THOMPSON Engineering Consultants, Inc.

November 2, 1999

**Re: RESUBMITTAL OF McDONALD'S/GAS STATION GRADING AND
DRAINAGE PLAN (J-14/D109)**

Submitted for your review is the revised Grading and Drainage Plan for the McDonald's/ Gas Station located at Broadway and Lomas. The following are responses to John Curtin's comments in his letter dated October 6, 1999.

DRAWN BY: DATE: OCTOBER 26, 1999 SHEET 2 OF 6

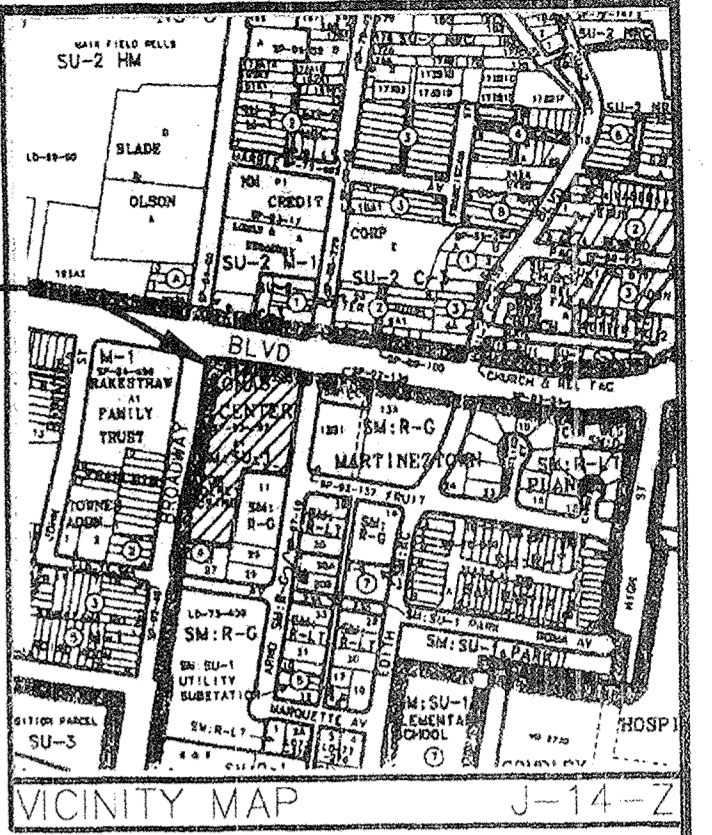
1. The lettering for the existing and proposed spot elevations has been enlarged to at least 0.10" so that it is more readable.
2. All curb elevations are top of curb elevations.
3. Existing storm drains in Broadway, Edith, and Arno have been added to the plan.
4. A copy of the infrastructure list is included in this submittal.
5. The DRB number is 99-297.
6. There are no off-site flows that enter the site.
7. The 50-foot surface drainage easement will be vacated as part of the plat action for the site.
